Rezoning Petition Review – Charlotte Tree Ordinance

Subject: Urban Forestry Rezoning Petition Review Summary

Rezoning Petition: 2021-104

Date	Description/Status
9/23/2021	UF 2 nd review, Tim Porter
8/26/2021	UF 1 st review, Tim Porter

Table with columns: FILE NUMBER: 8085-02, DATE: 04/12/2021, REZONING PETITION #2021-104 SCHEMATIC SITE PLAN, BEECHWOOD JACKSON, LLC, FERNCLIFF TOWNHOMES, and other project details.

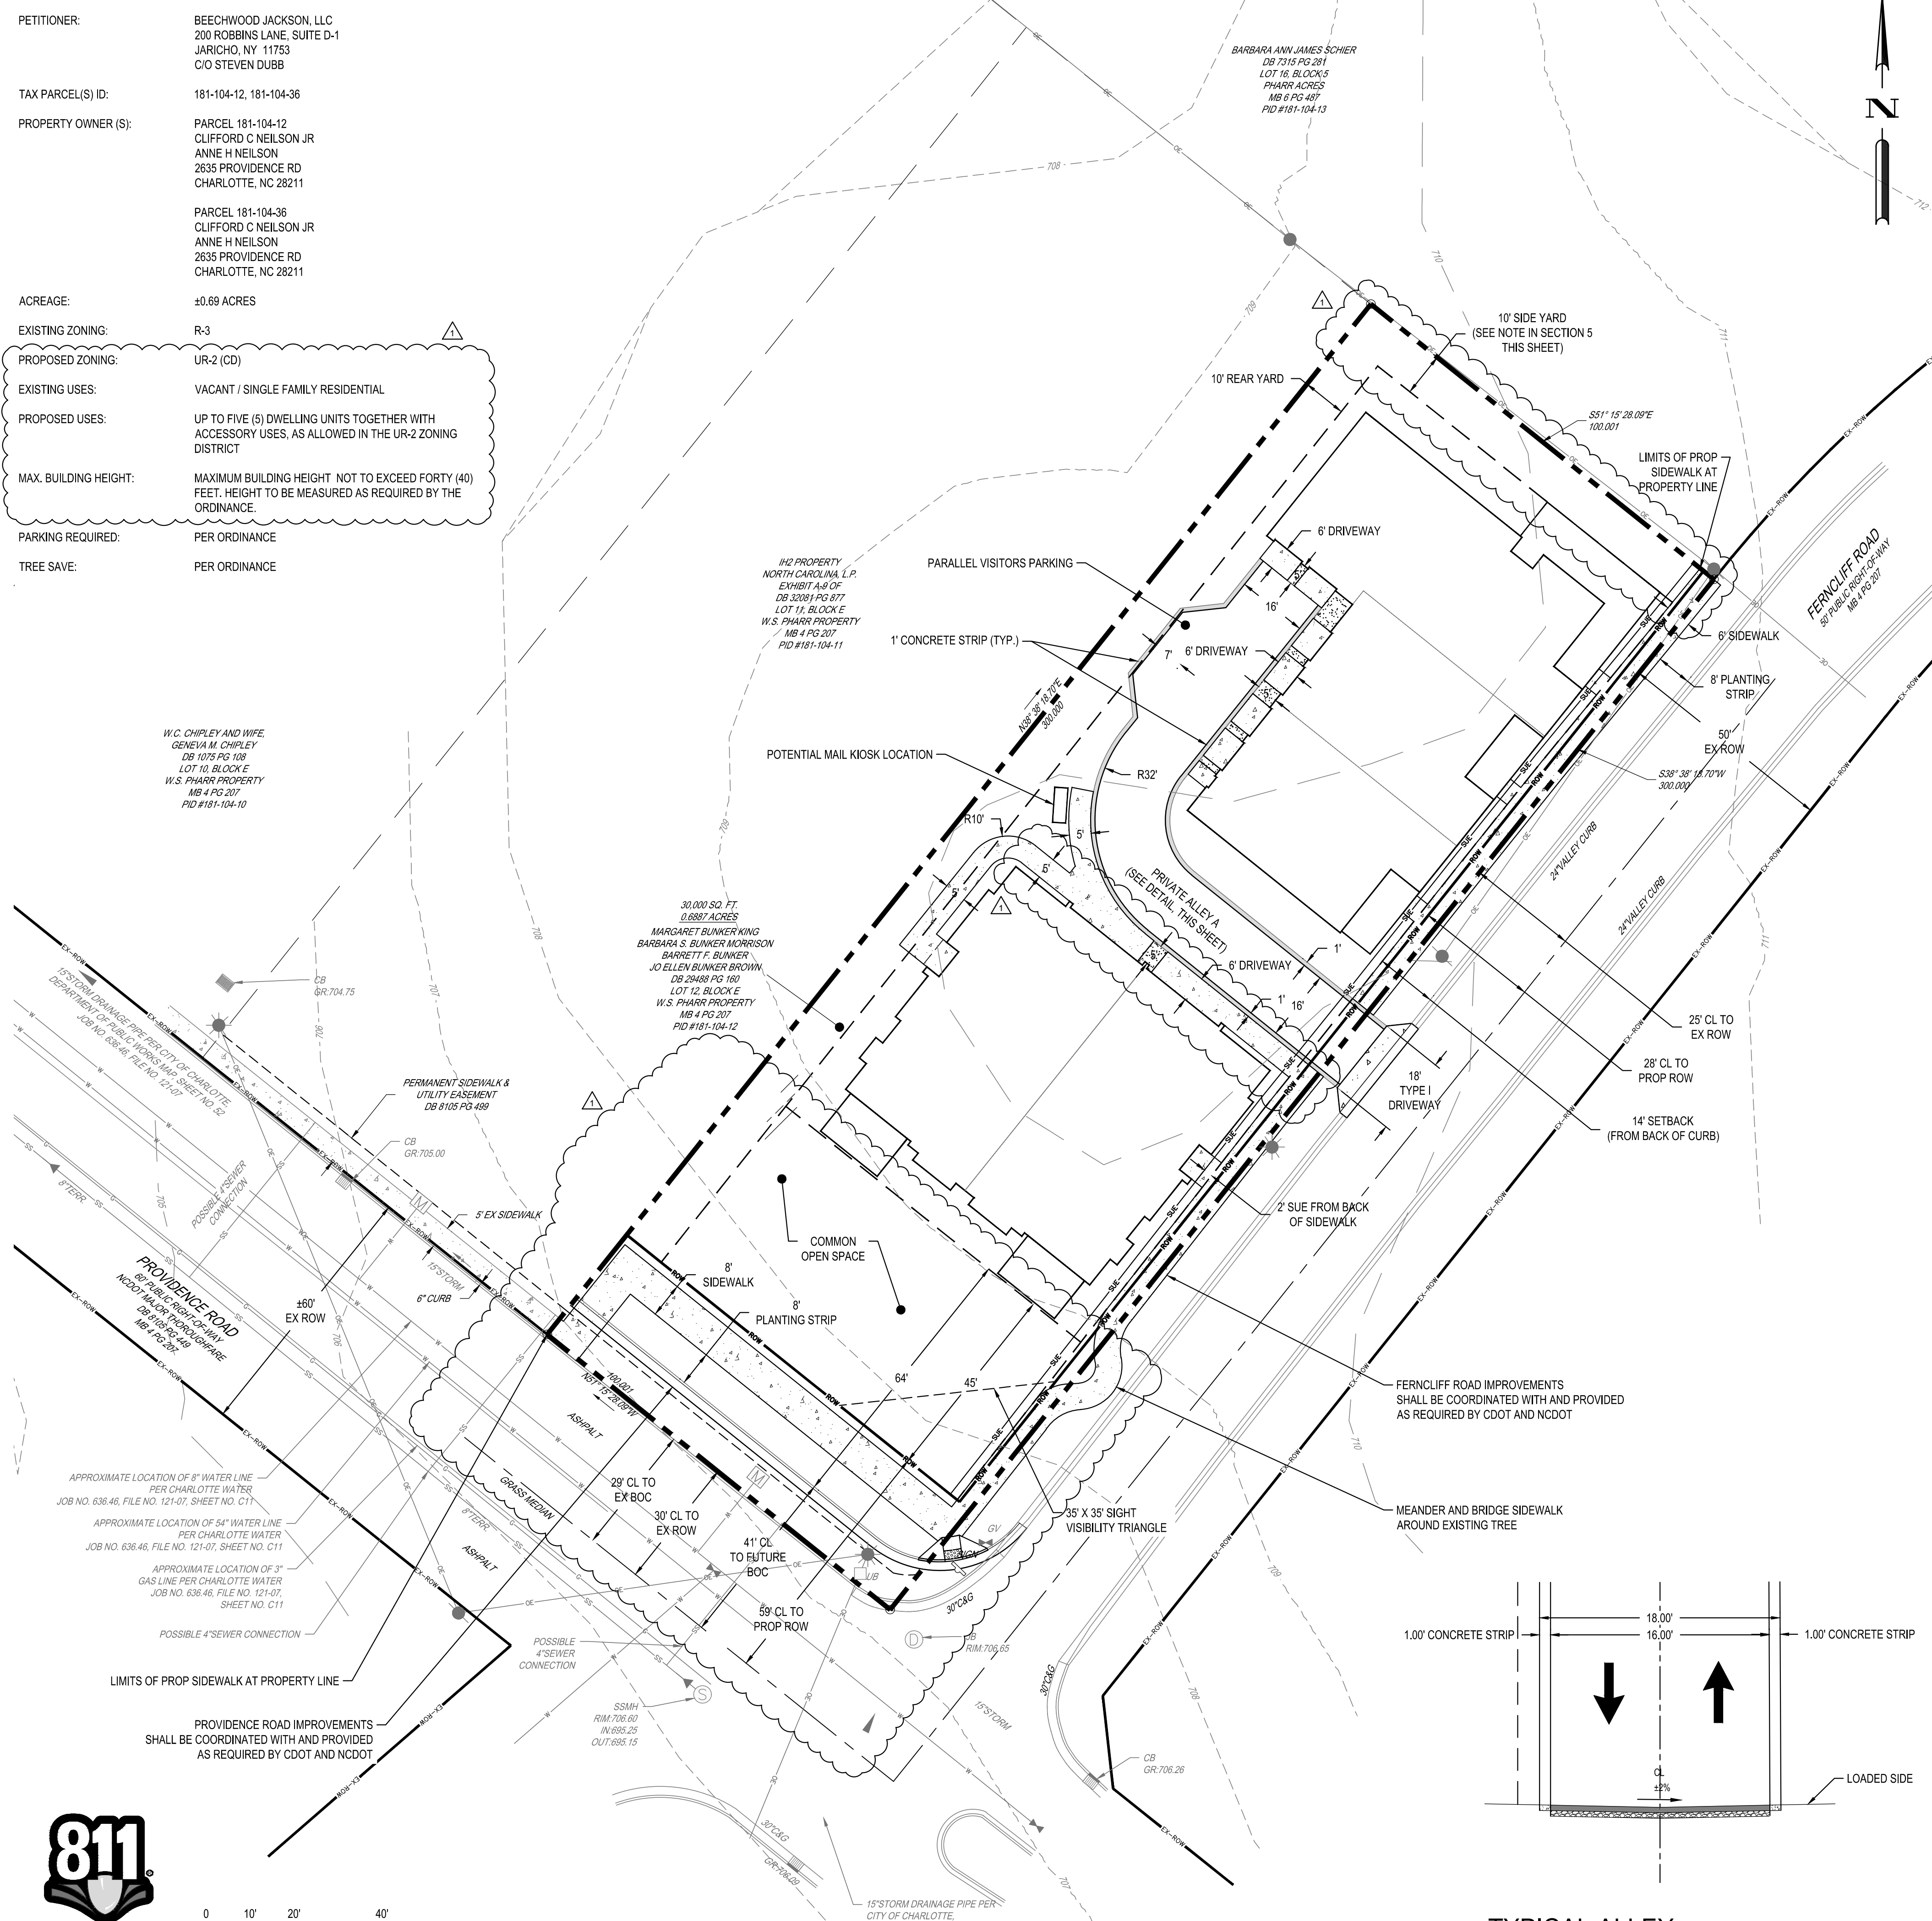
- ~~— A tree survey shall be submitted identifying all trees of eight inch (8) dbh or greater and all planted trees of (2) two inch caliper or greater and six feet in height that grow partially or wholly within public street right-of-way.~~
